REQUEST

Current Zoning: N1-A (Neighborhood 1-A)
Proposed Zoning: N2-A(CD) (Neighborhood 2-A, Conditional)

Approximately 7.96 acres located south of Sunset Road, west of Gutter Branch Drive, and east of Oakdale Road.

The petition proposes the development of up to 80 multi-family attached residential units, the site is occupied by one single family home.

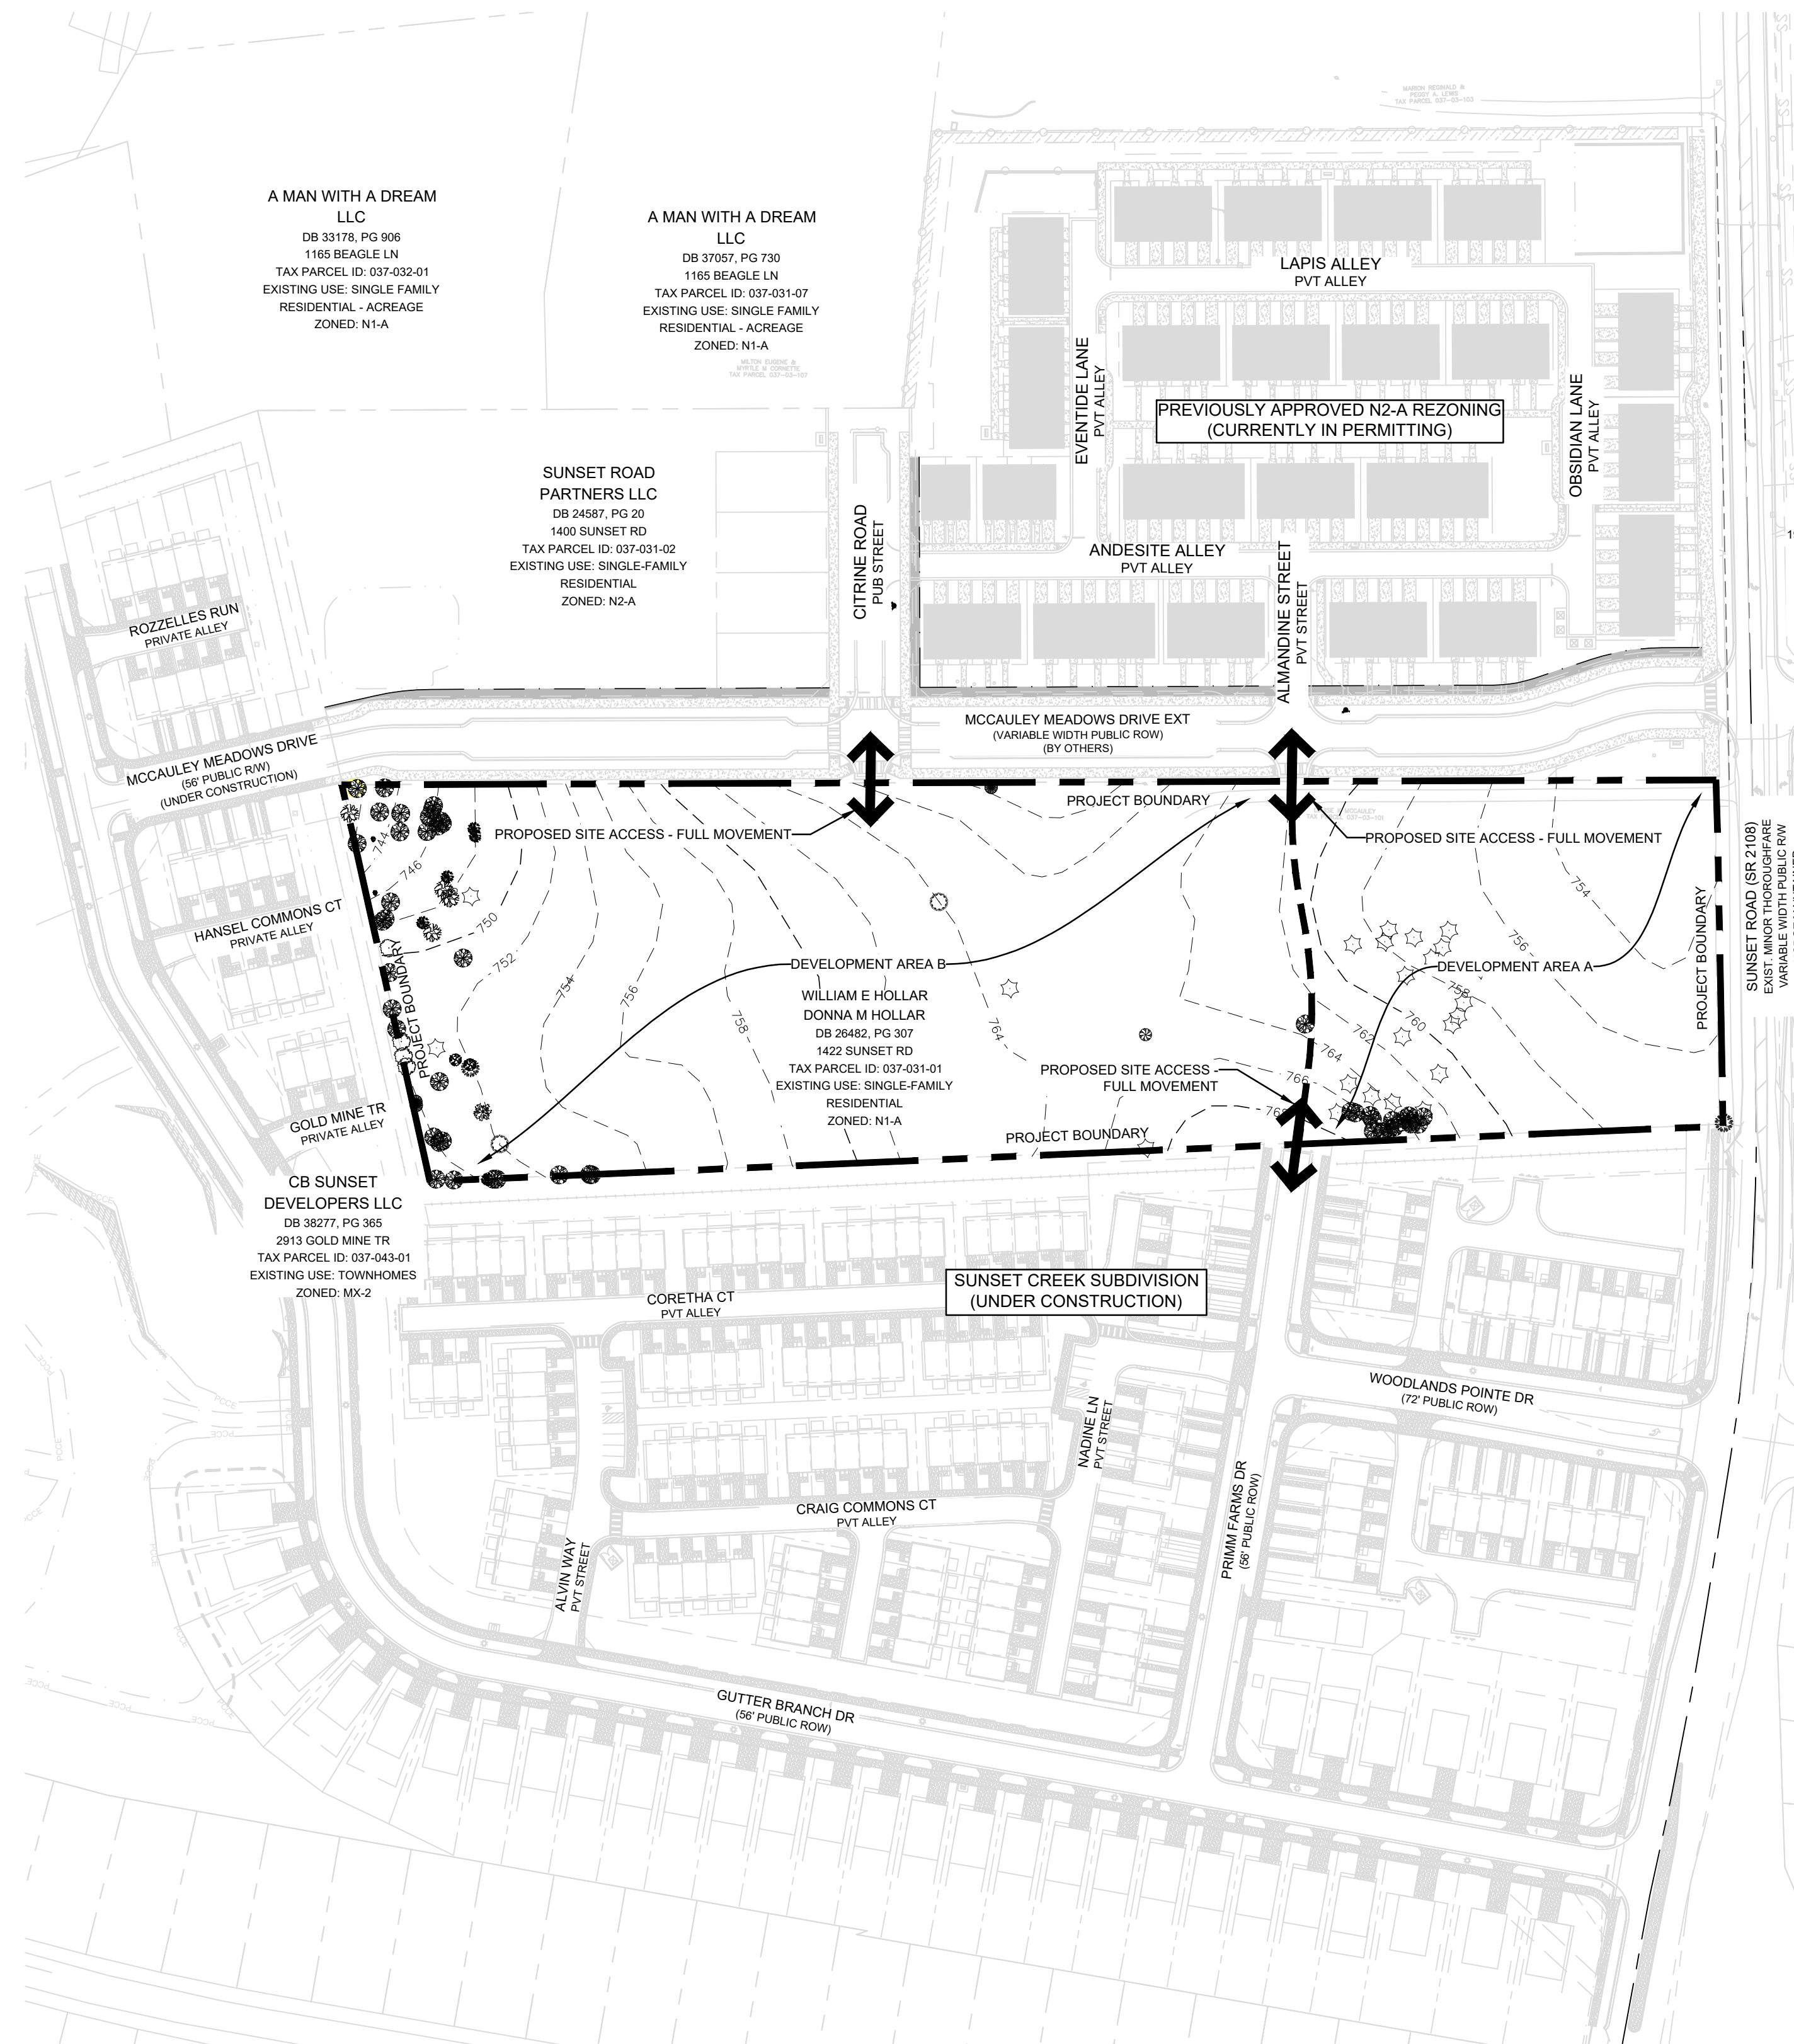
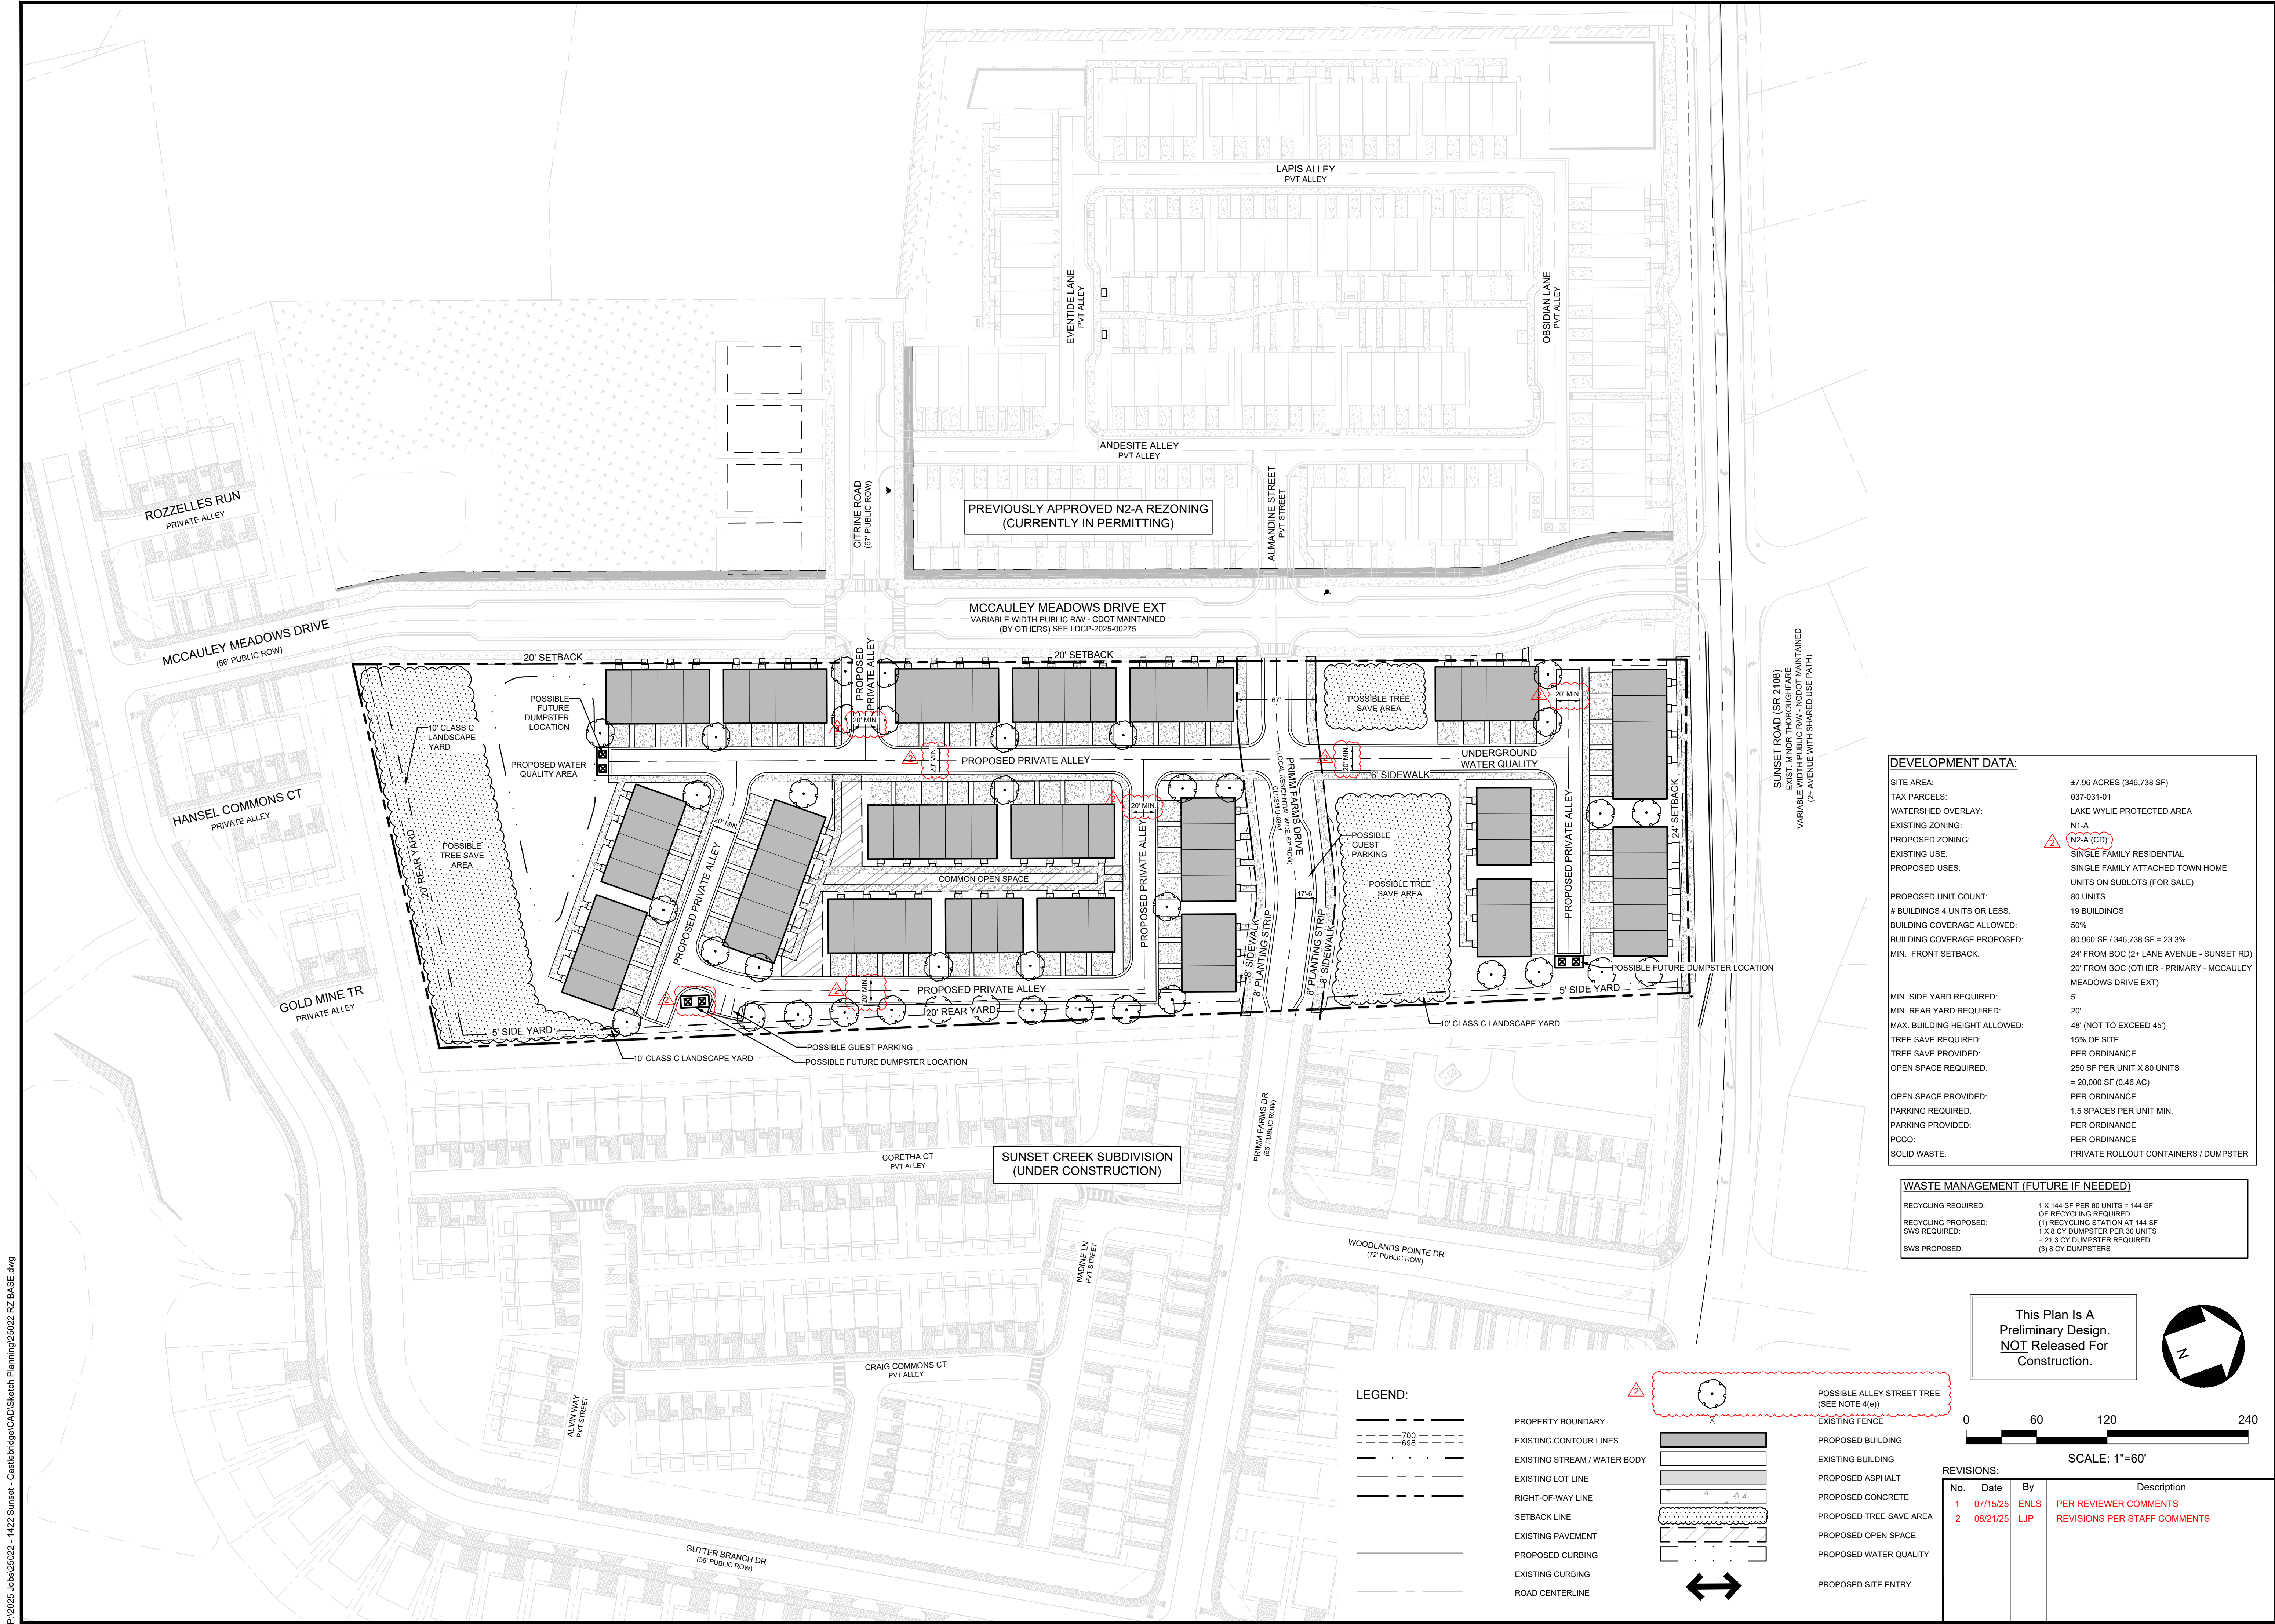
1. ~~Solid waste facilities should be located at least 25' from property lines, see Article 21.4.A., confirm compliance and revise location shown on the site plan.~~ **Addressed.**
2. ~~Revise architectural standards to just list prohibited building materials rather than preferred materials.~~ **Addressed.**
3. ~~Add street trees along alleys and commit to maximum spacing.~~ **Addressed.**

4. ~~Label and dimension the curb and gutter from the centerline for each road on the site plan.~~ **Partially Addressed.**
5. Label McCauley Meadows Drive as U-03A1 for reference on the site plan. **Outstanding**
6. Label and dimension what the future right-of-way of McCauley Drive will be. **Outstanding**
